DEVELOPMENT REVIEW COORDINATOR
POST APPROVAL PROJECT CHECKLIST

Project Name: Mixed Use - Cope

Project Address: 23 Ocean Ave.

Site Plan ID Number: # 2016-150

UTILITY & STORMWATER MANAGEMENT PLAN

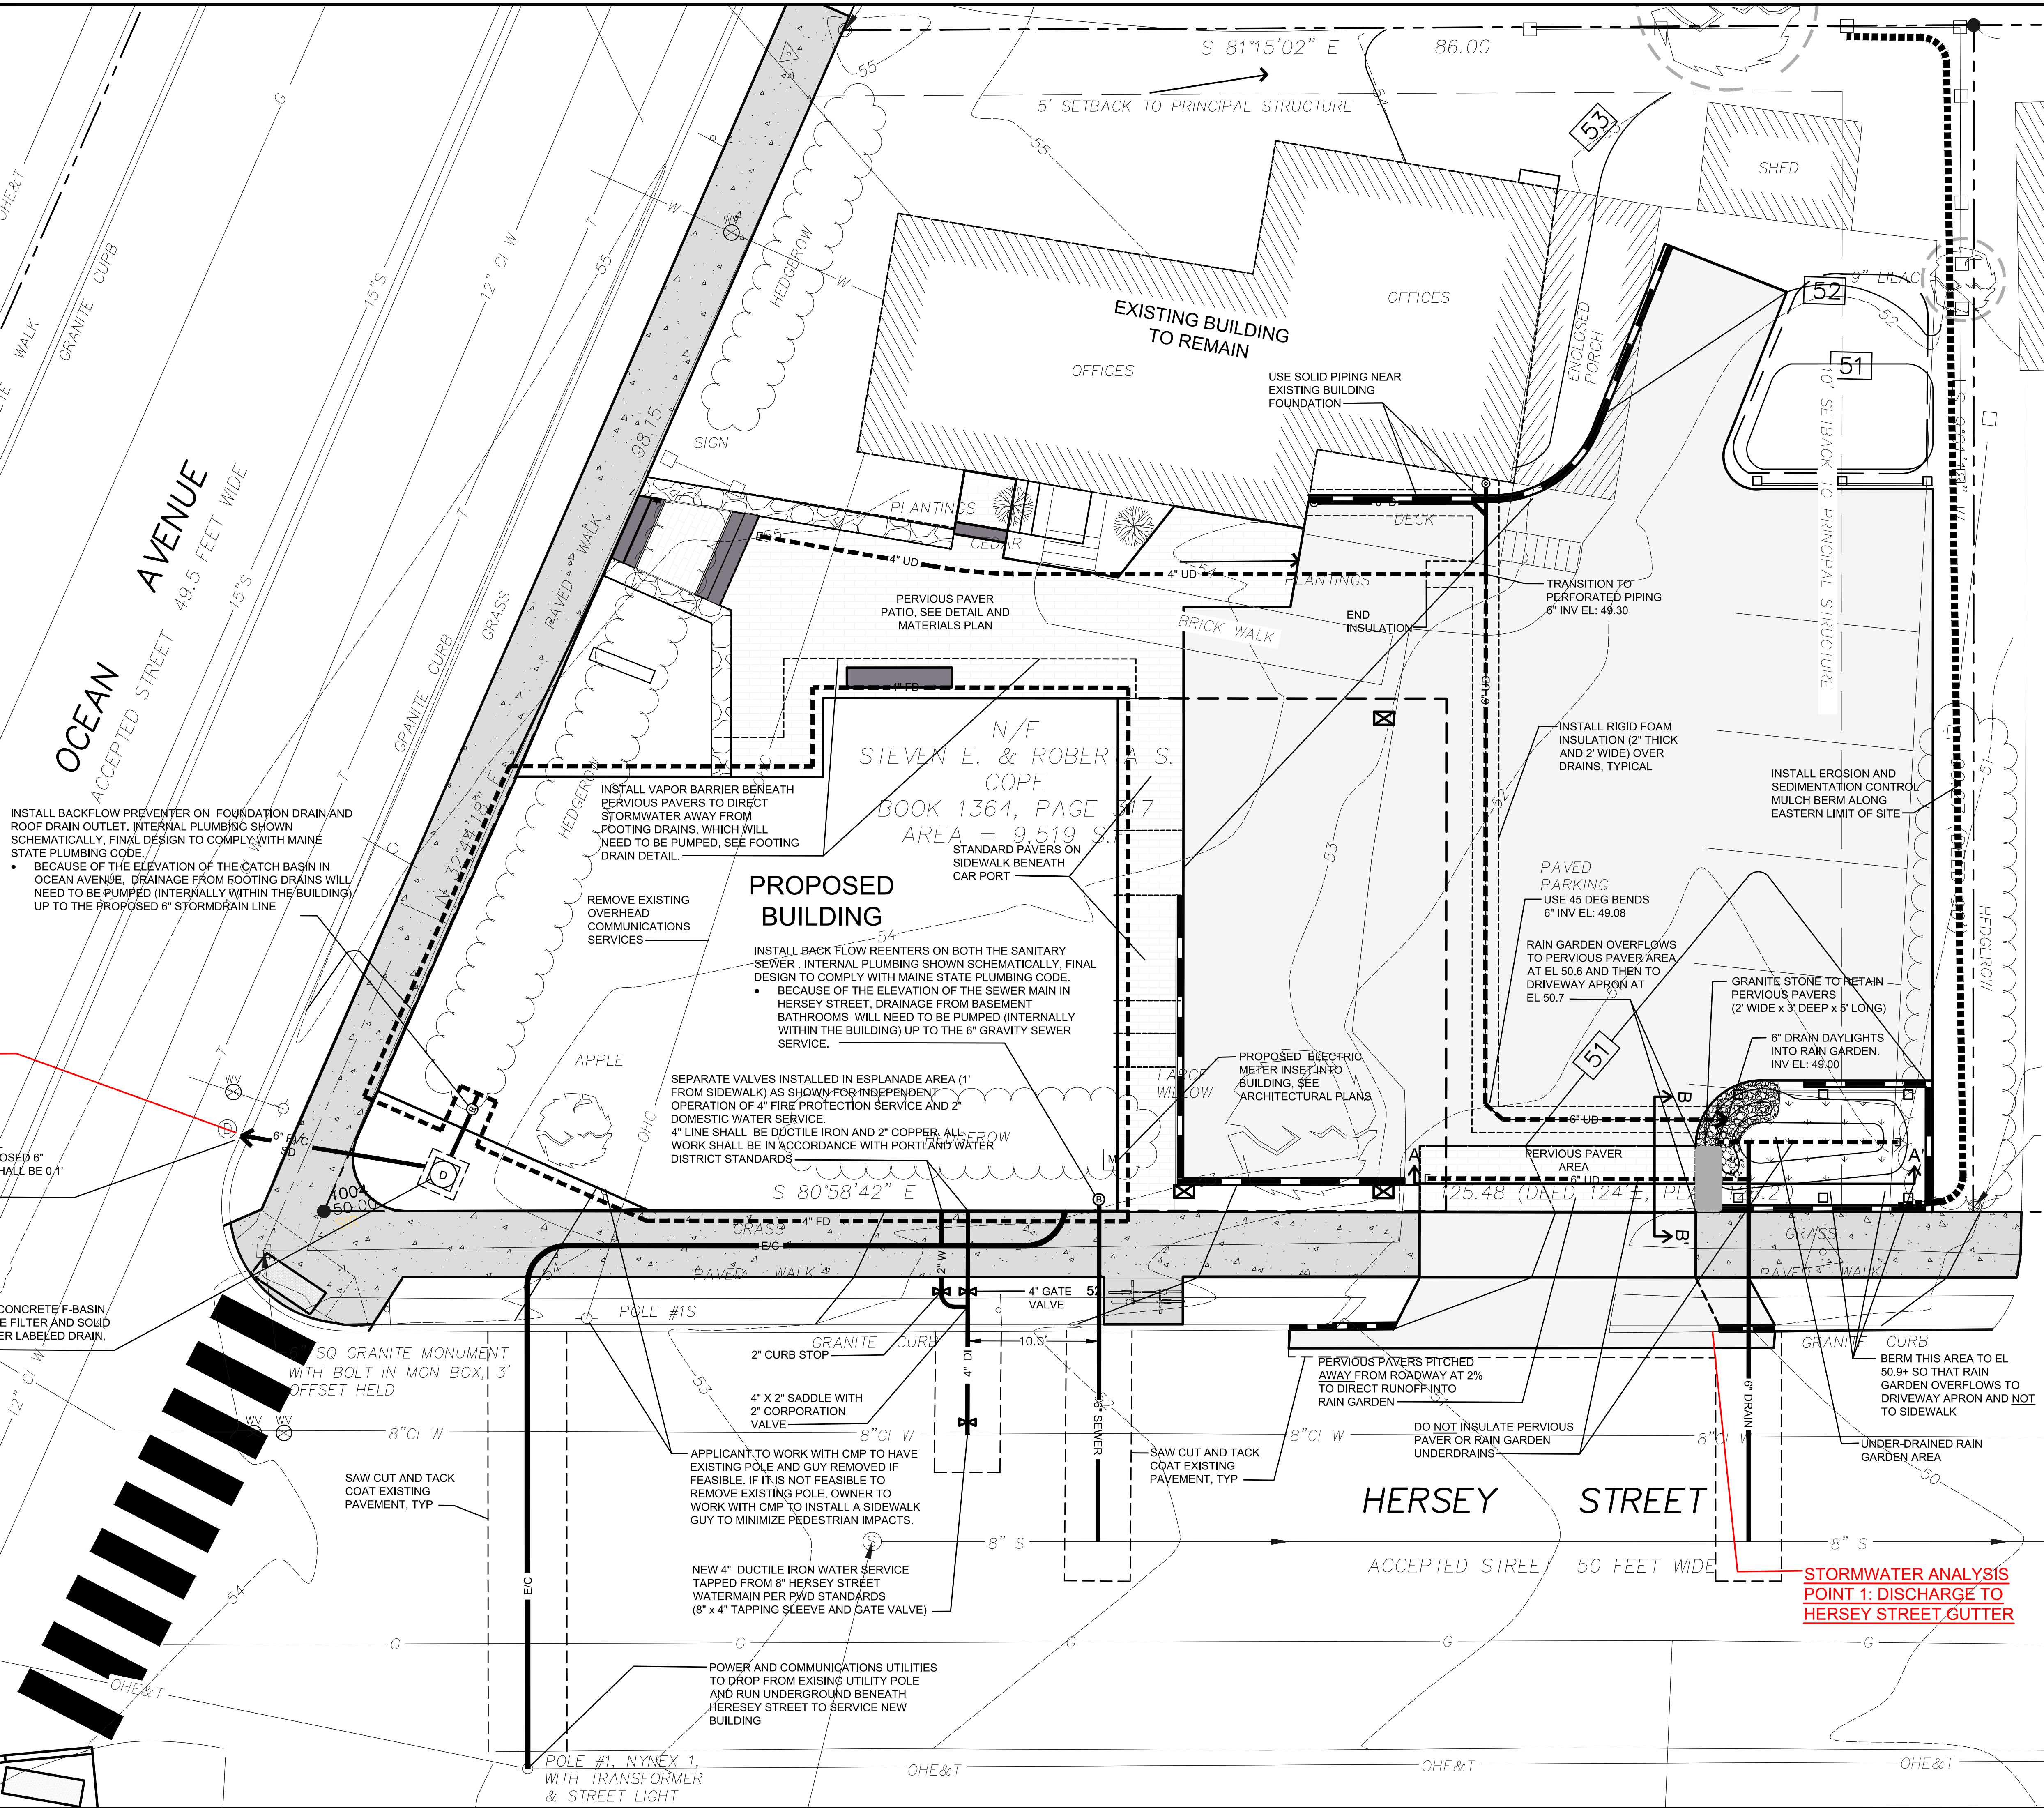
- 6. Snow storage shall not impinge on the on-site parking. Snow shall be hauled off site as needed; and
- 7. The applicant shall provide revised plans to address the conflict between the proposed cherry tree and stormwater treatment unit at the corner of Ocean Avenue and Hersey Street for review and approval by the City Arborist and the Planning Authority.

Off Street Parking Diagram

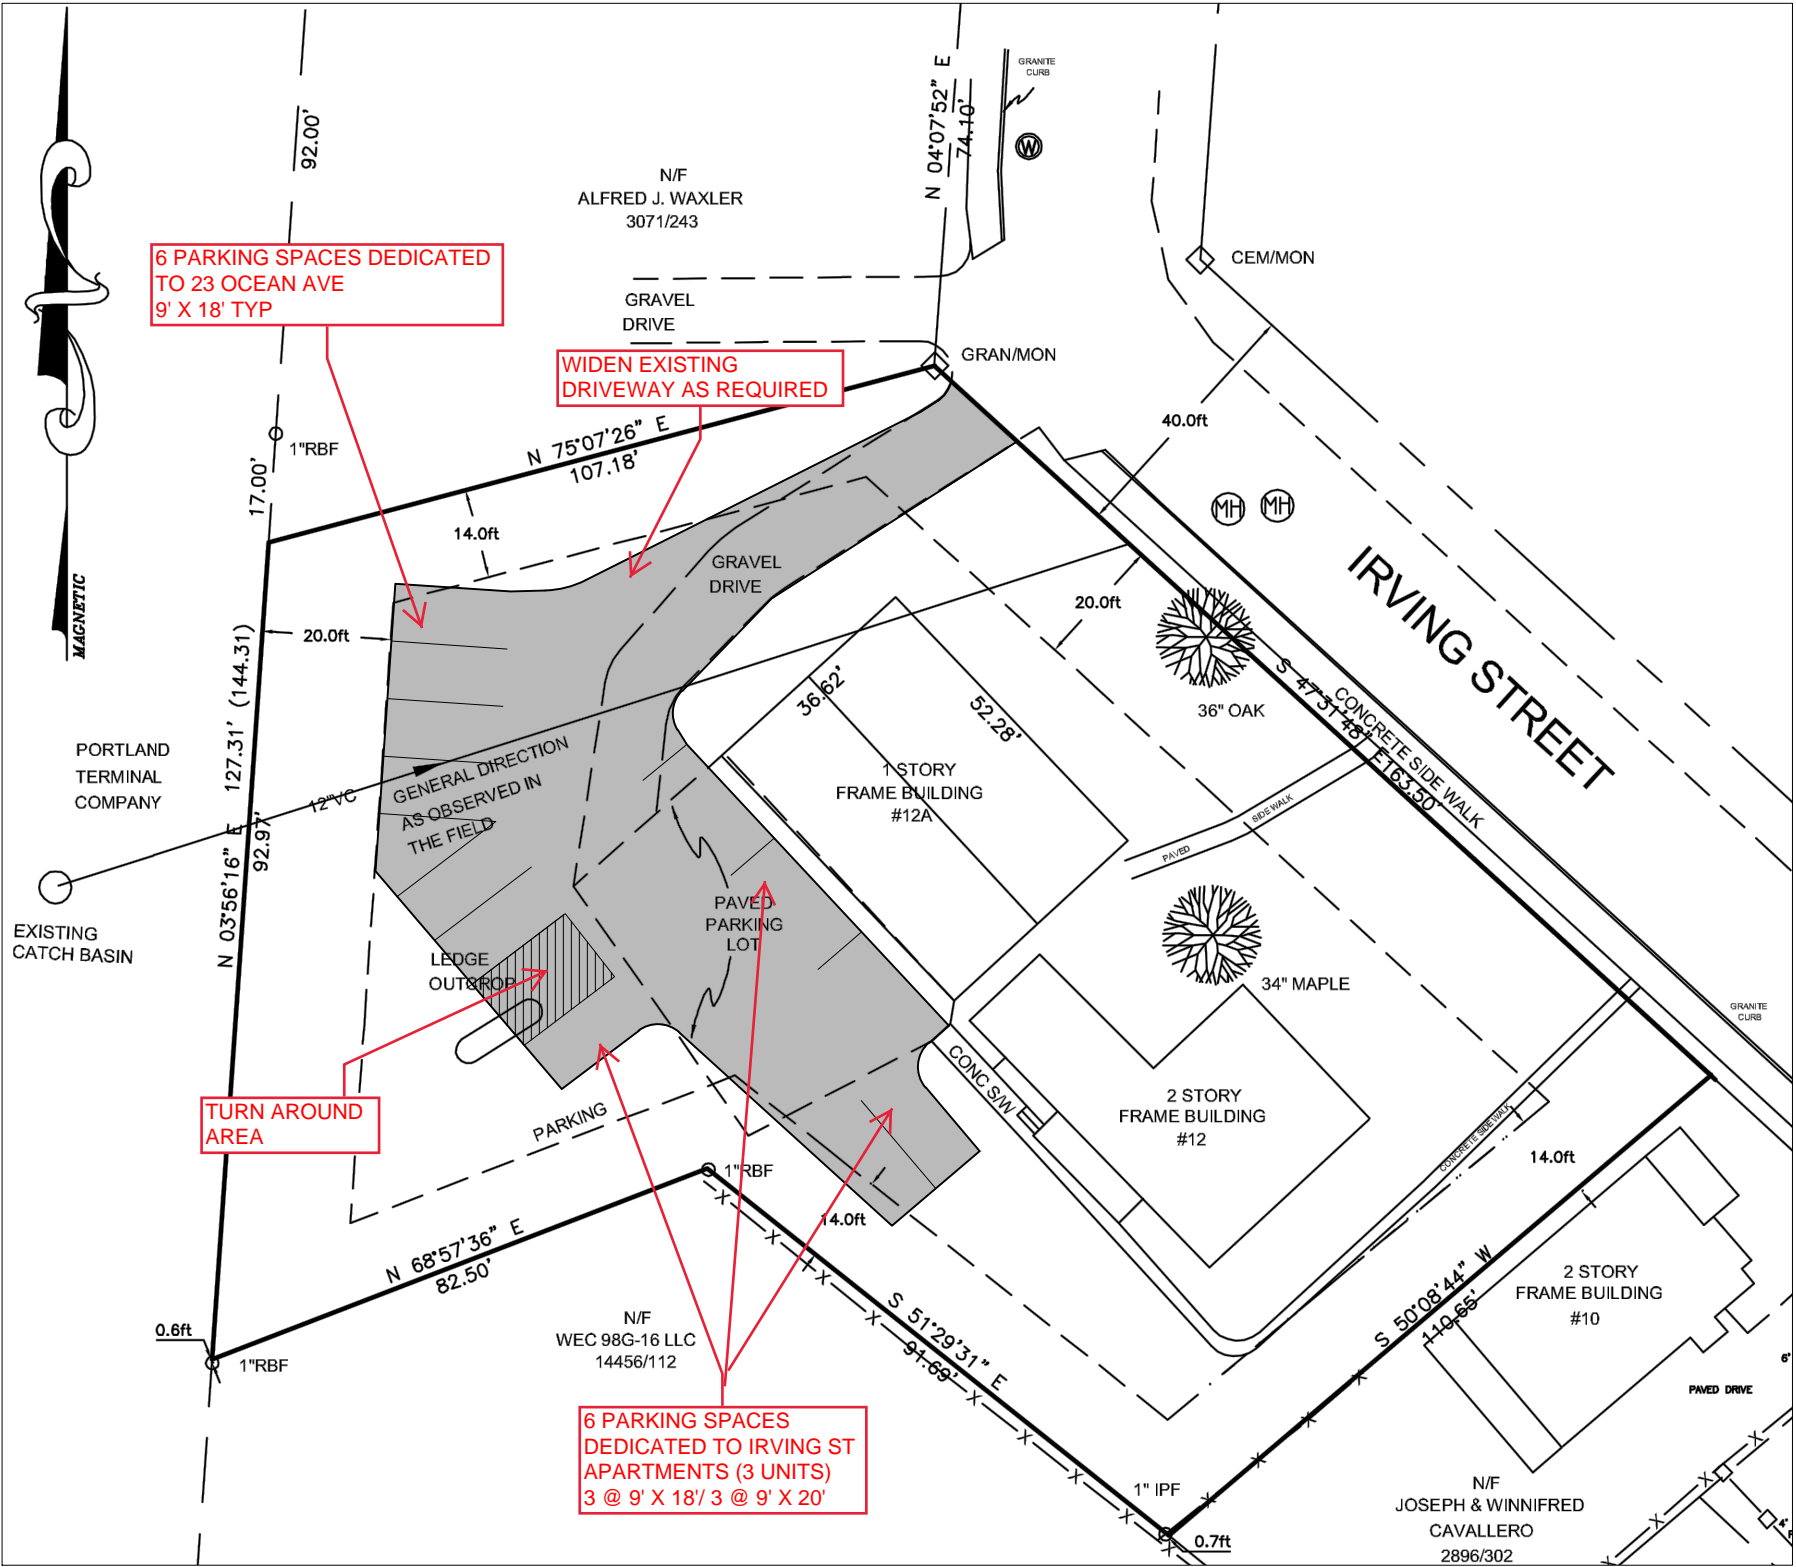
3. Prior to the issuance of certificate of occupancy, the applicant shall provide a signed, notarized lease for the use of off-site parking spaces in compliance with *Section 14-334* of the city's land use code for review and approval by the Planning Authority and Corporation Counsel;

FINAL SITE/SUBDIVISION PLAN
 OF: 23 OCEAN AVENUE
 PORTLAND, MAINE
 FOR RECORD OWNER:
 23 OCEAN AVENUE ASSOCIATES, LLC
 P.O. BOX 1398
 PORTLAND, MAINE 04104
 PLAN DATE: 06/04/2016

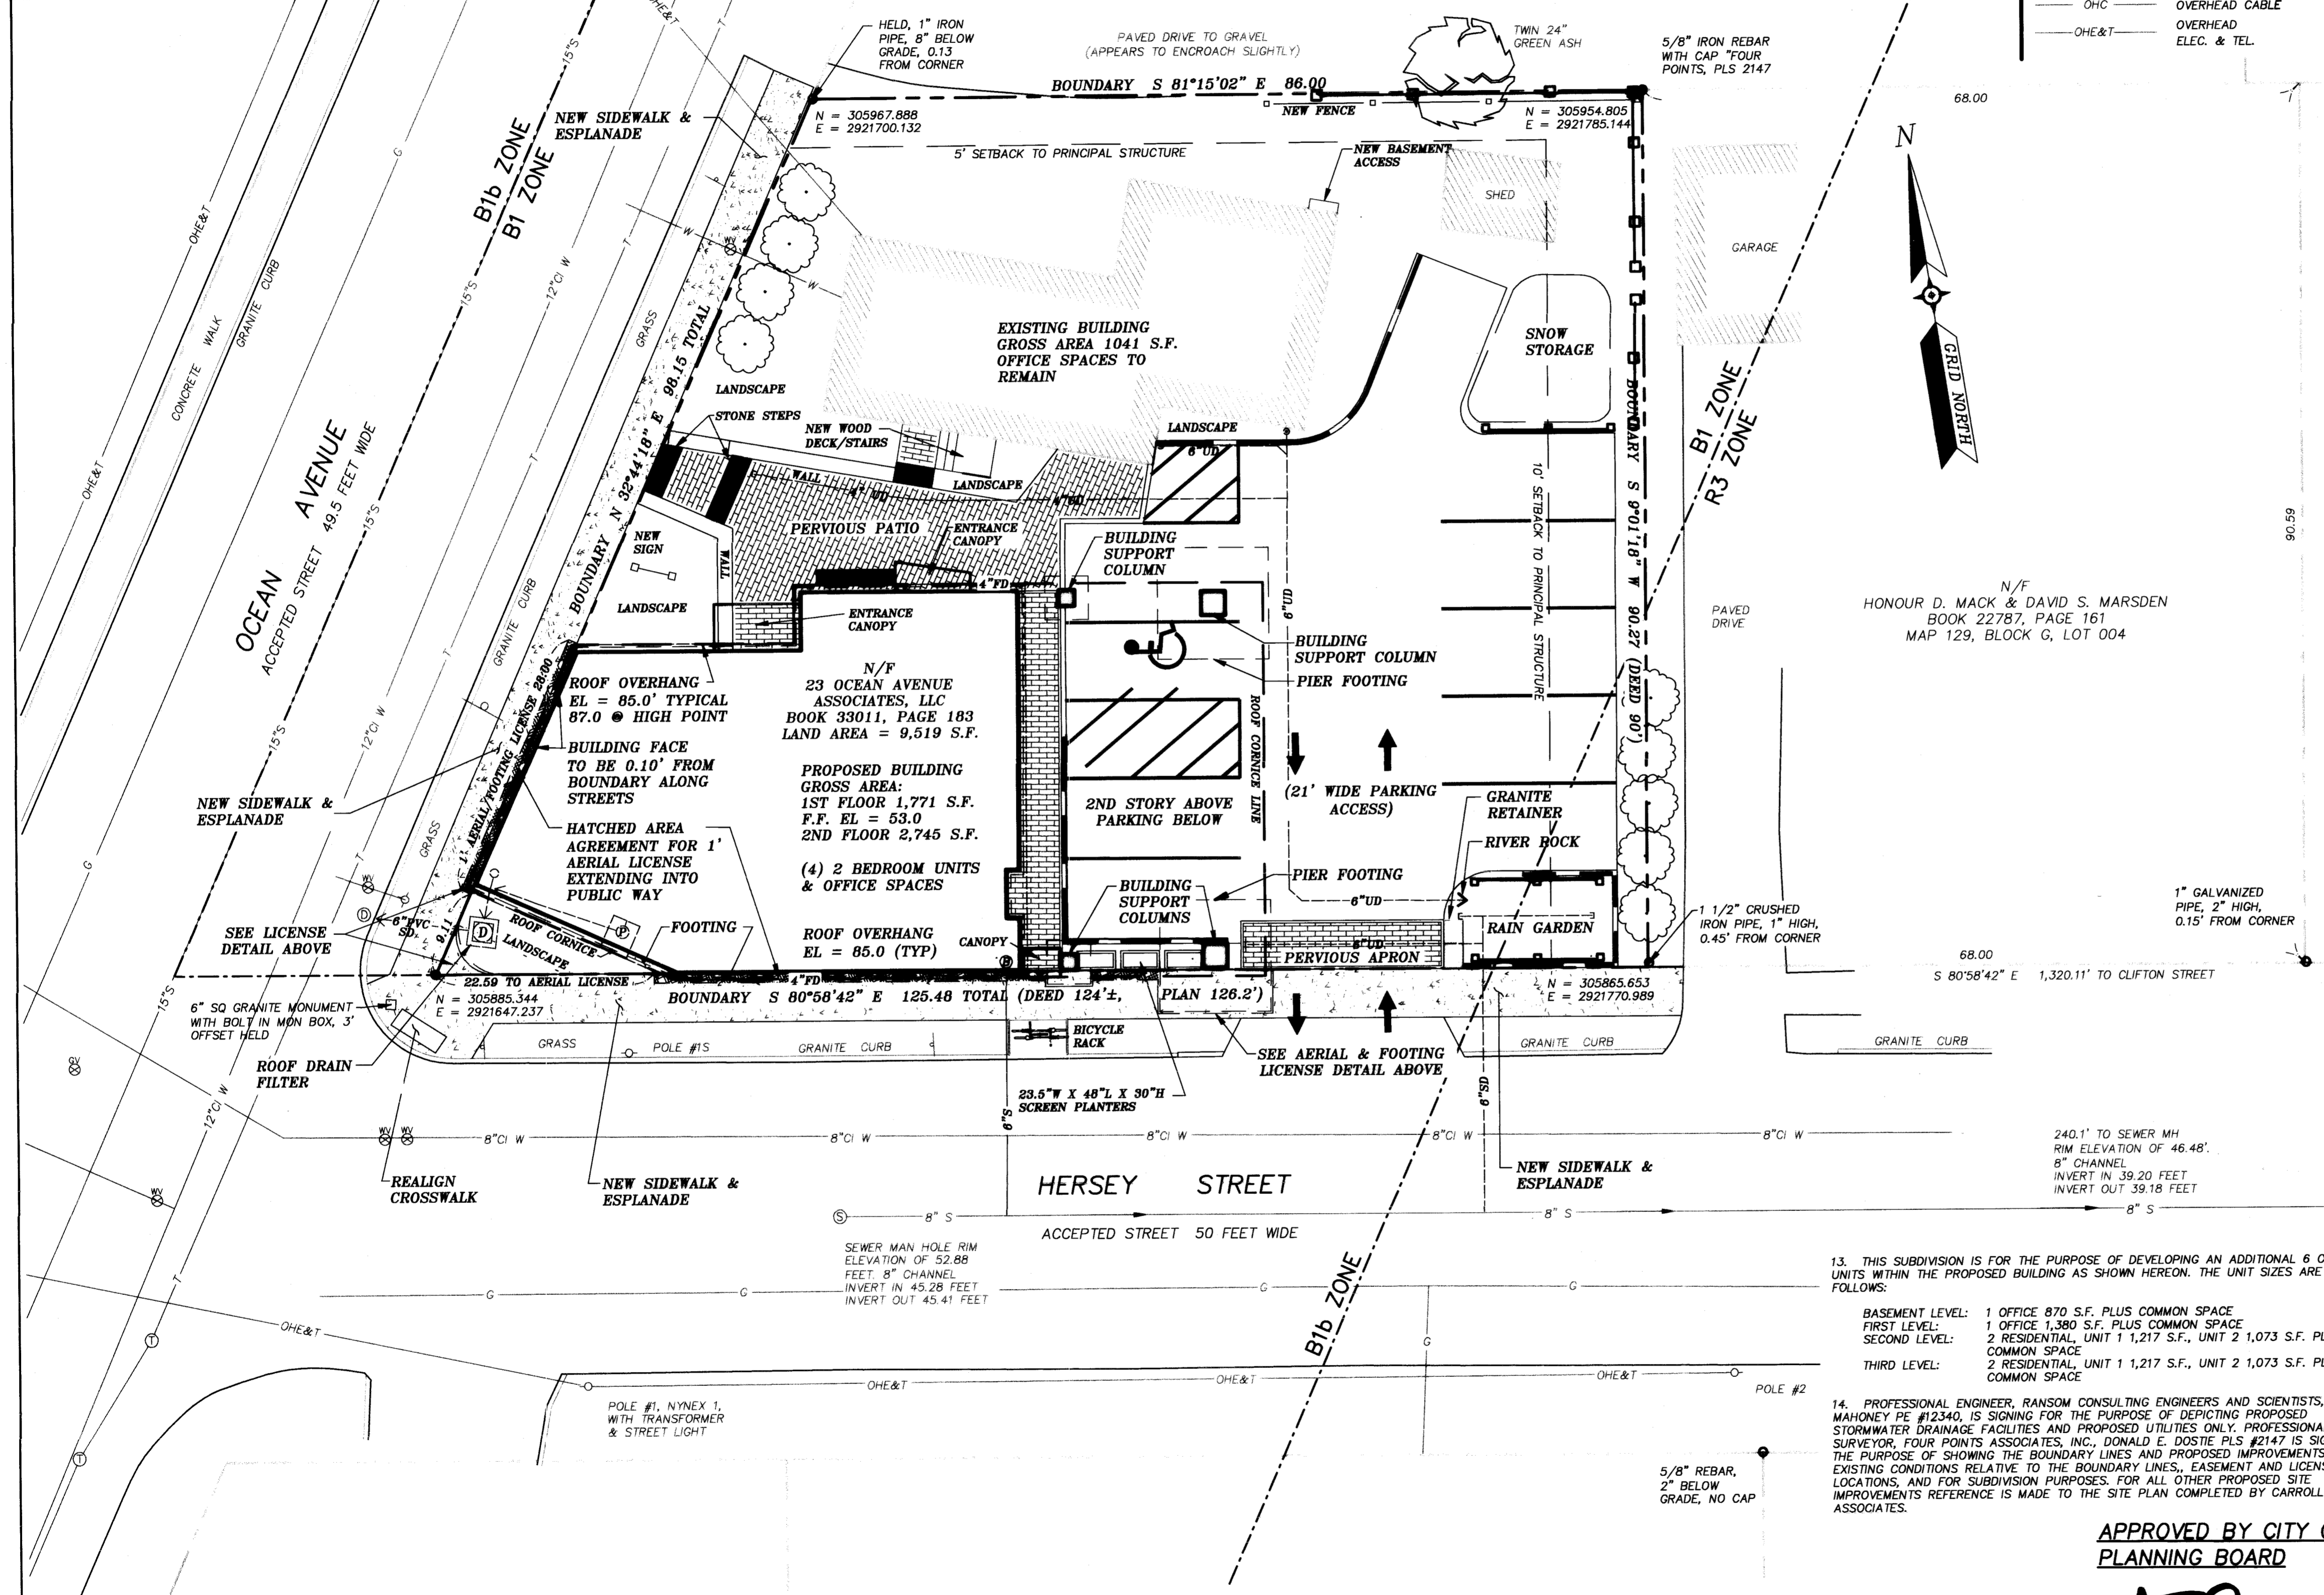
1. The applicant shall finalize the subdivision plat for review and approval by Corporation Counsel, the Department of Public Works, and the Planning Authority; and
